CITY OF ALBUQUERQUE

December 2, 2011

**Re: Country Club Place, 1816 Central Ave SW, (J13/D011),
Permanent Certificate of Occupancy - Approved
Approved Engineer's Stamp date: 4/5/11,
Certification dated: 12-1-11**

sheet  
**CG-101**

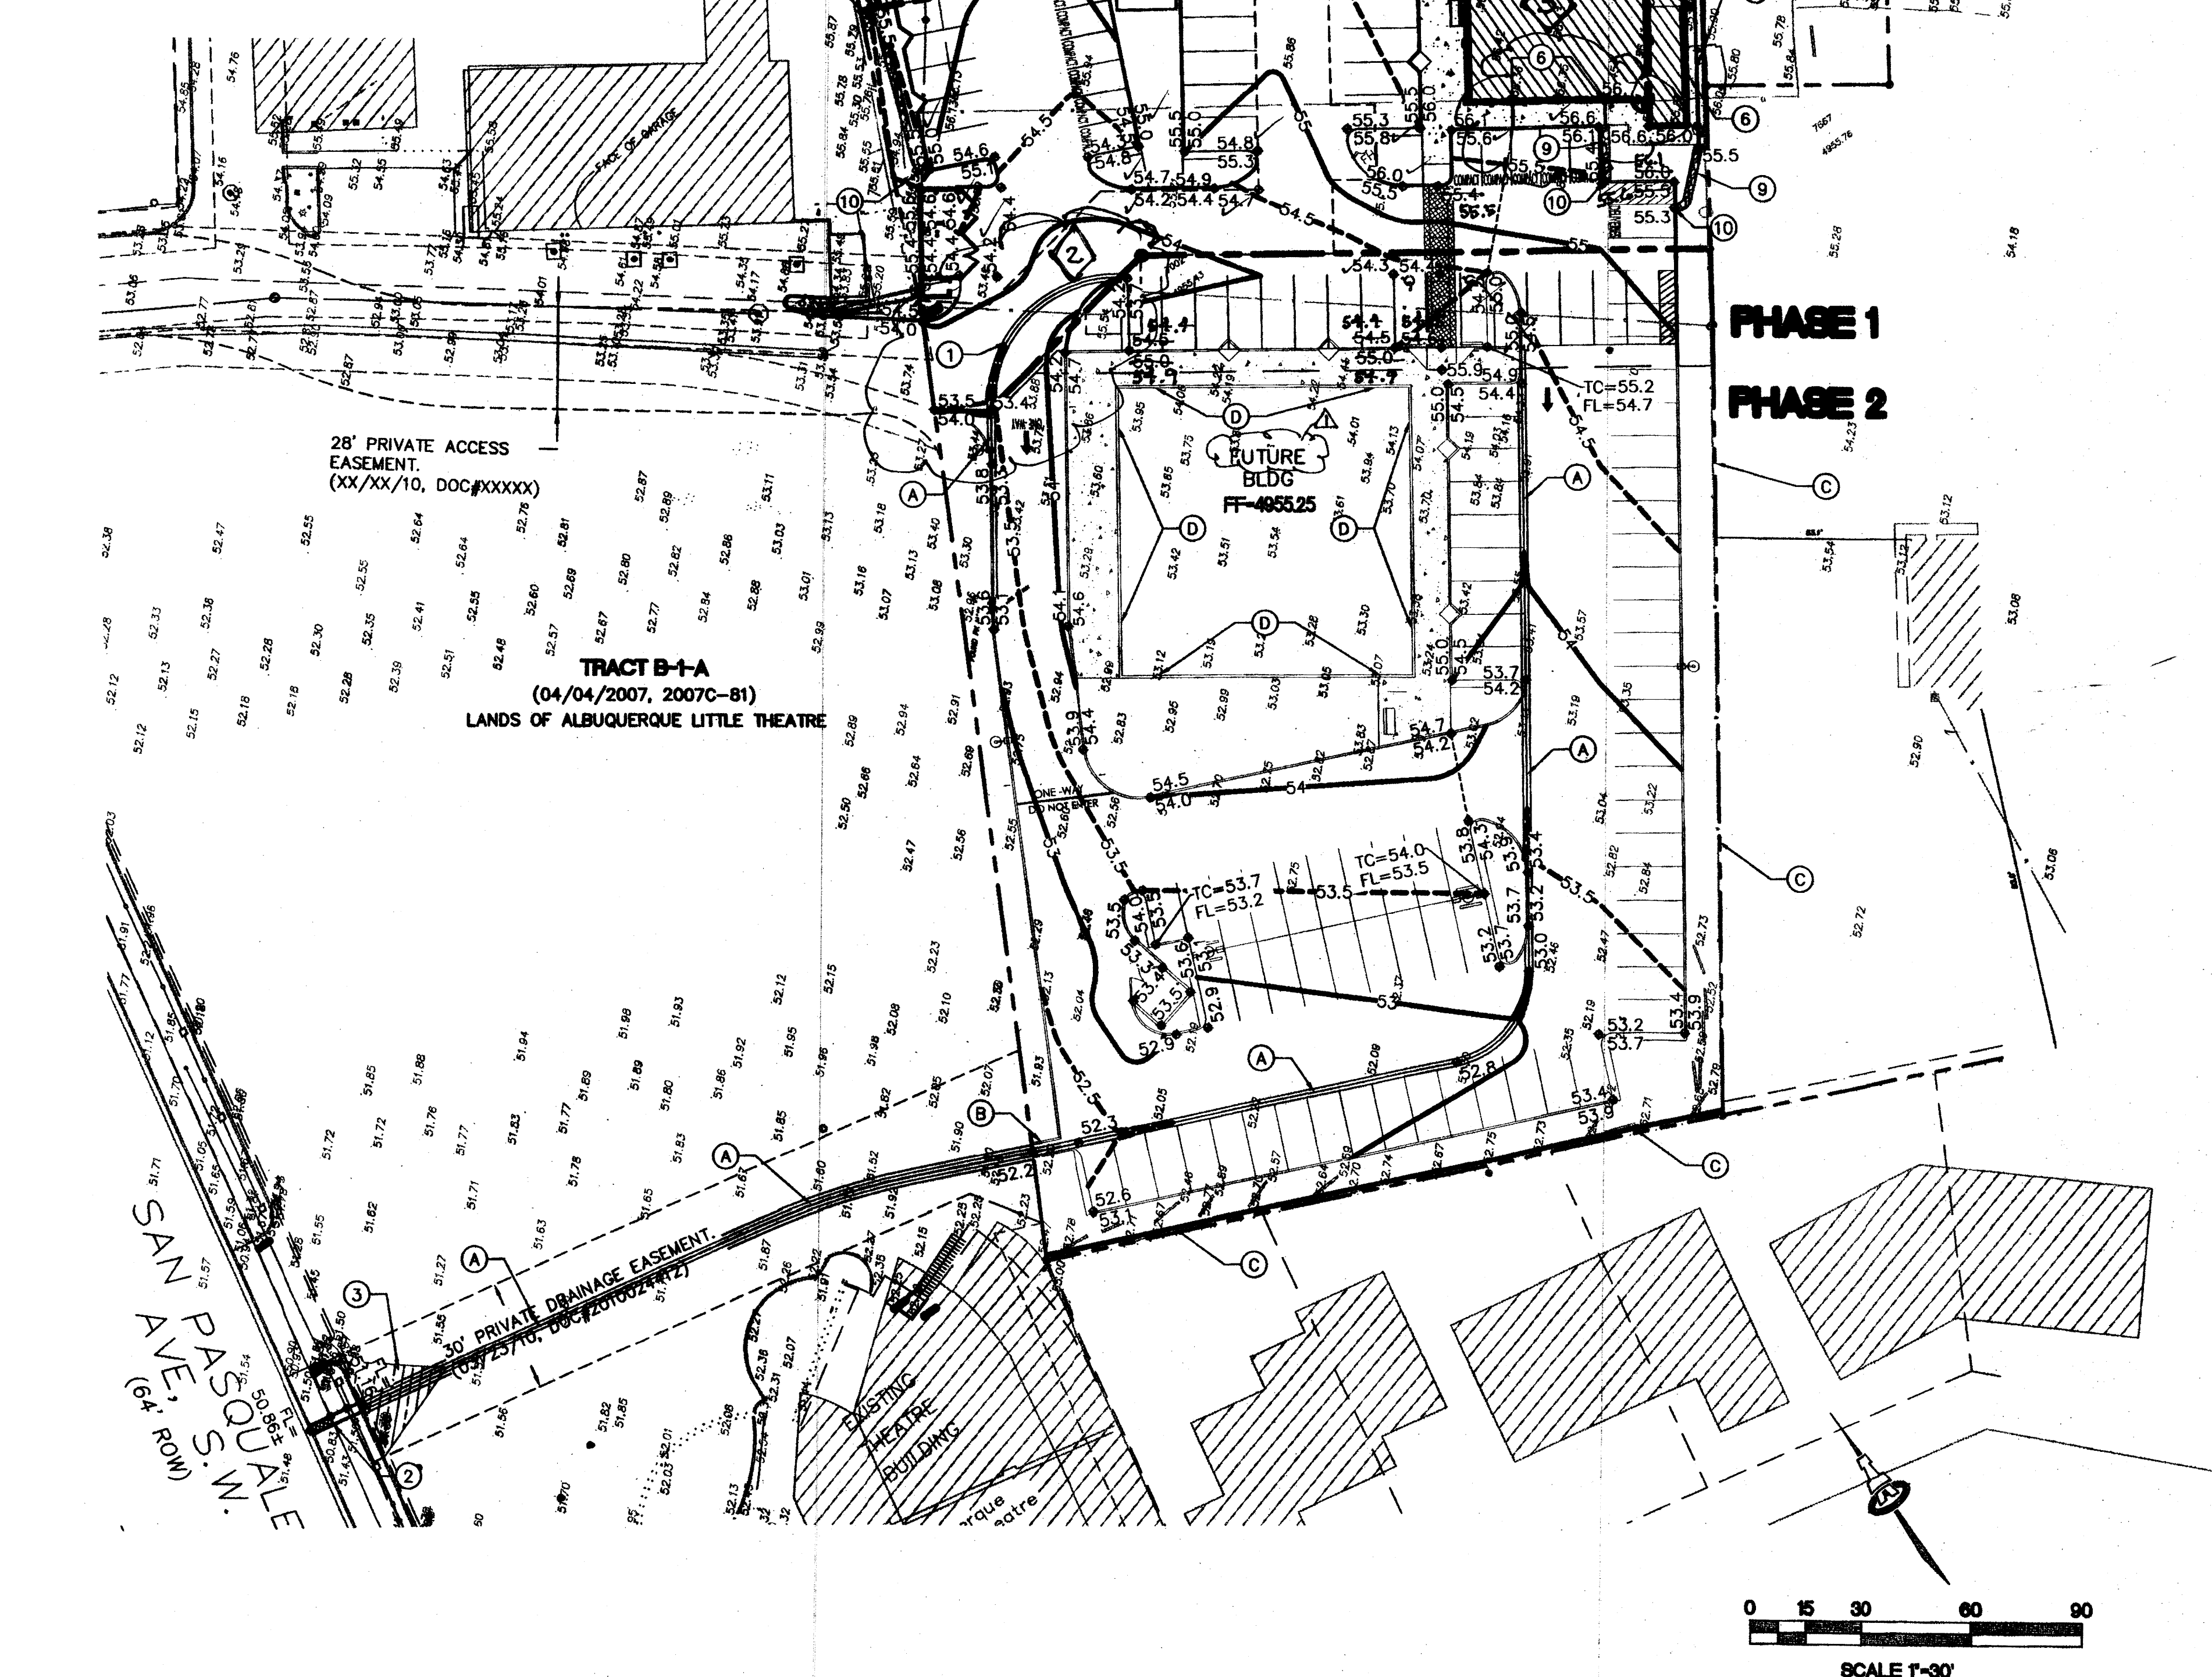
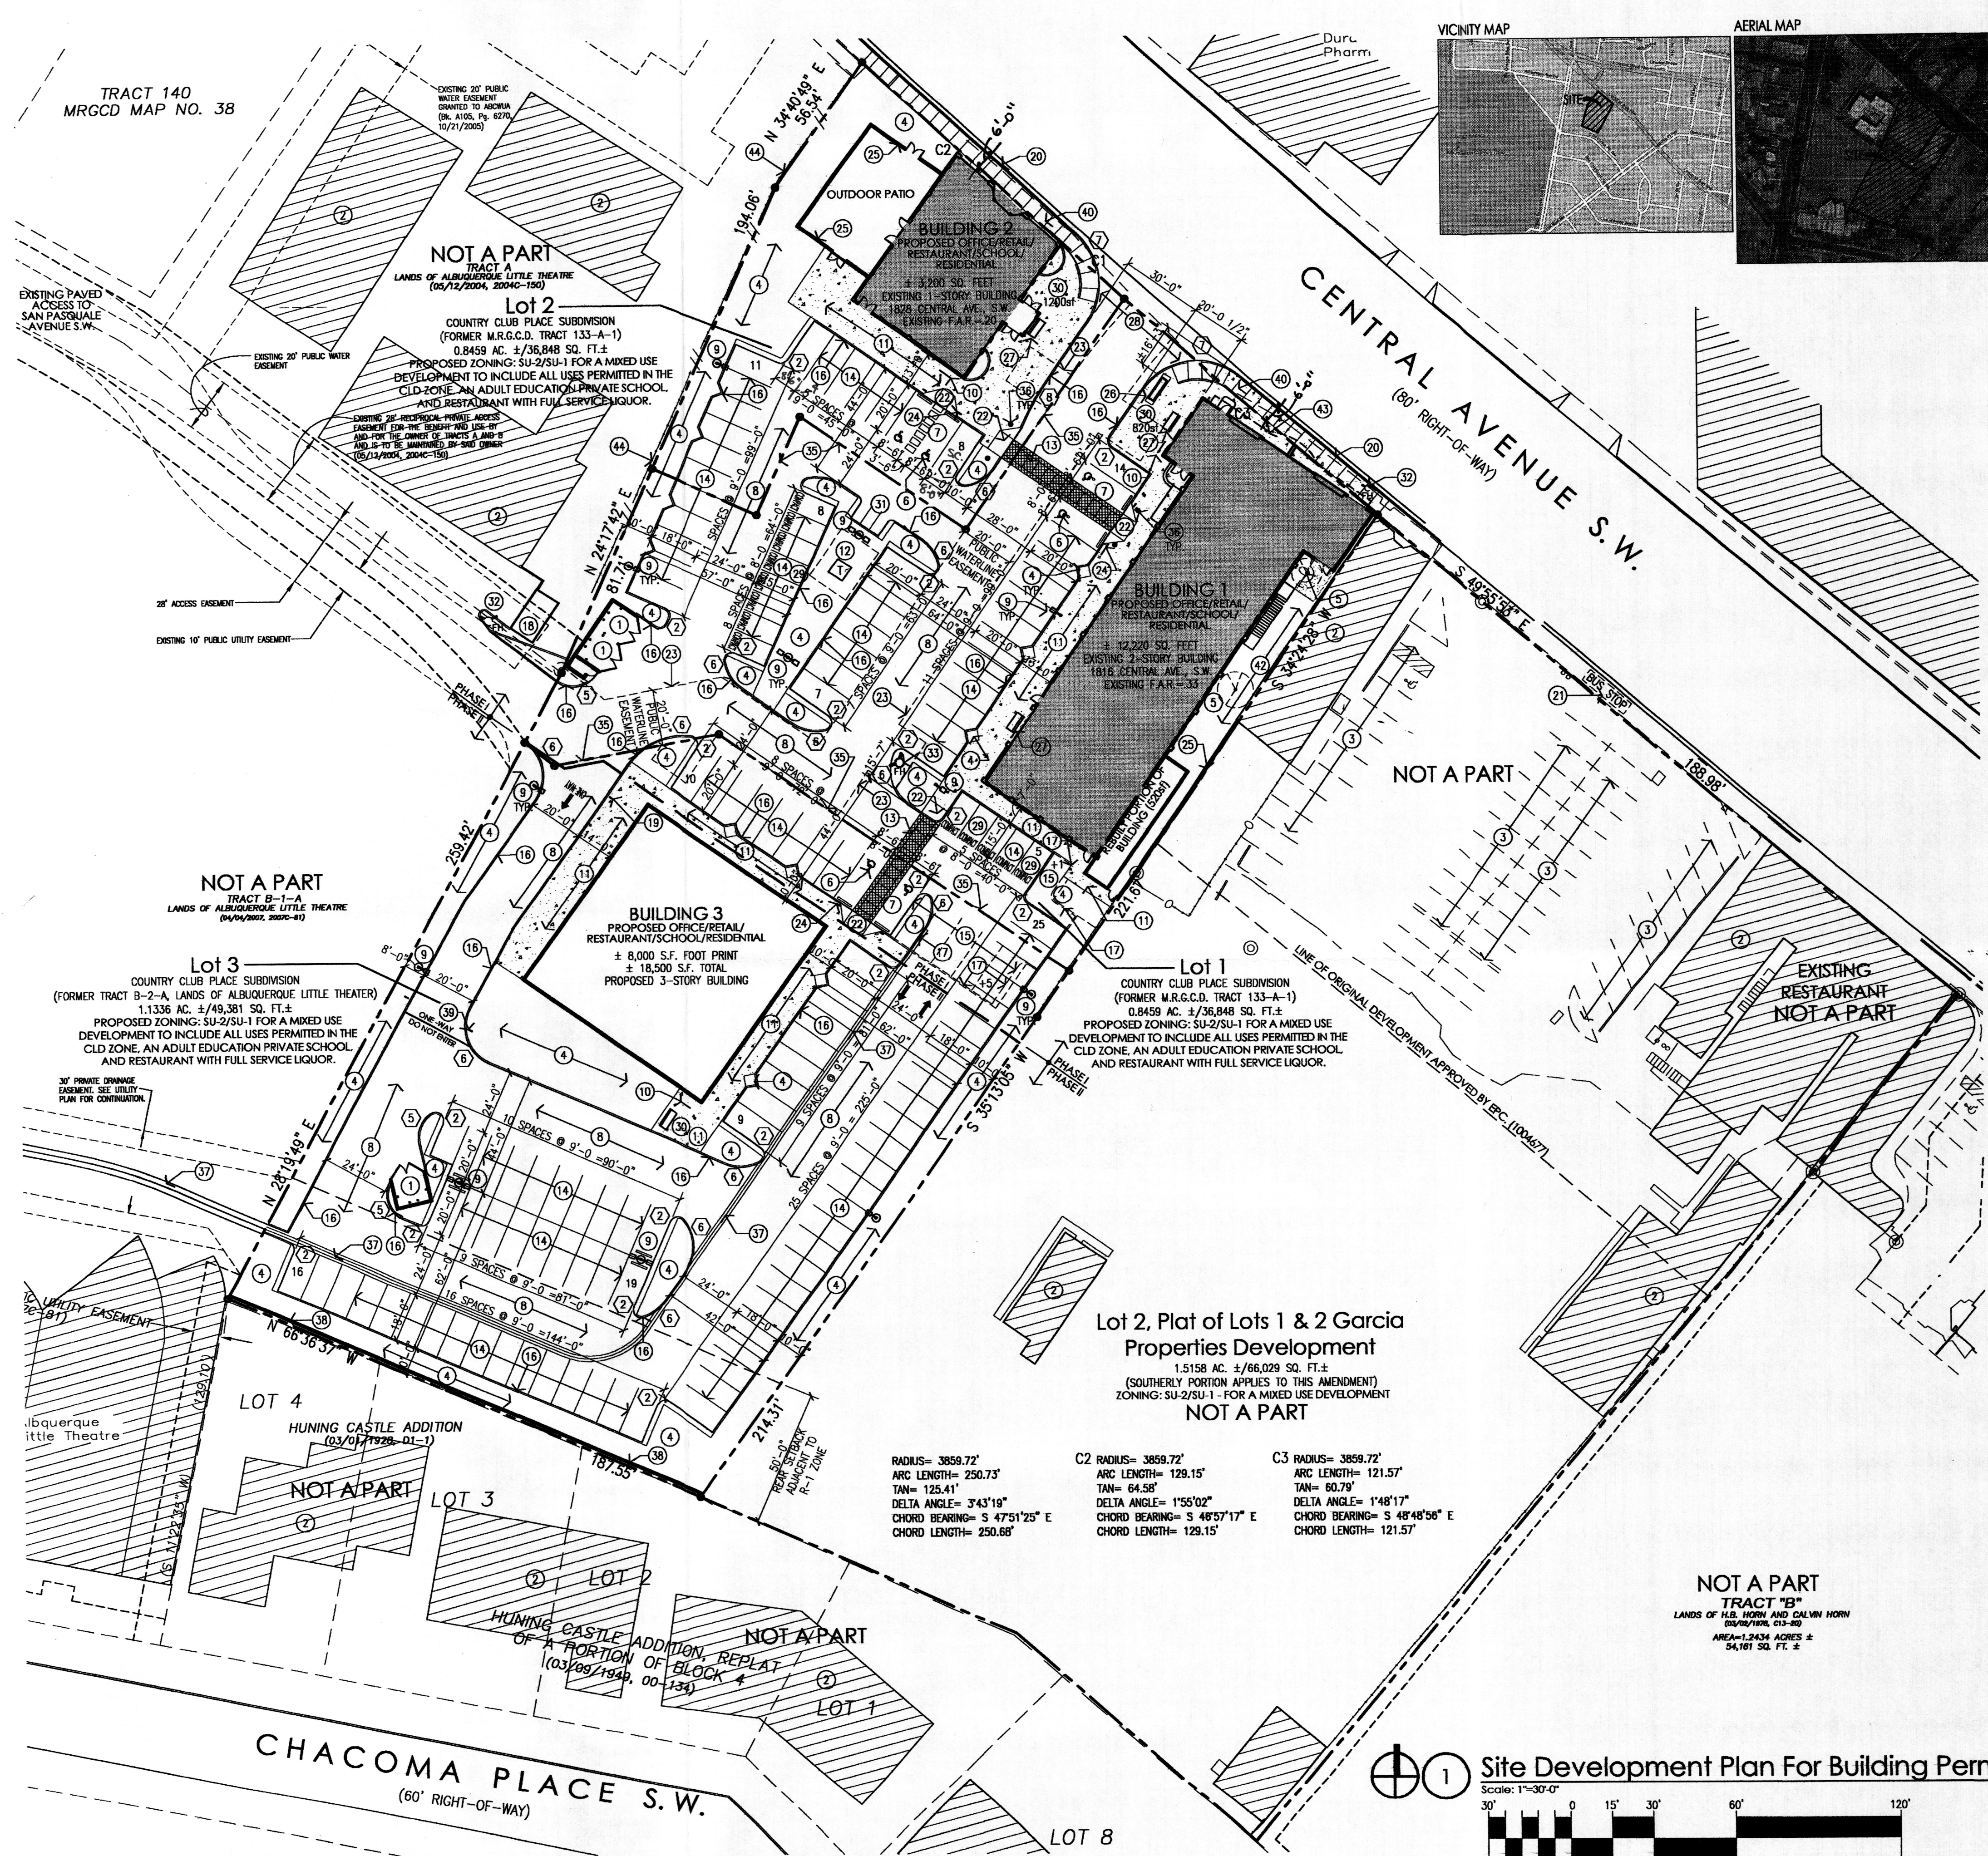
- The drainage addressed in Certification Note 2 is to drain south or an easement and capacity analysis to drain west/not per plan is required.
- Keyed Note 13 is to be changed to what is built or the trench drain is to be built.
- The sidewalk culvert on San Pasquale is to be constructed.
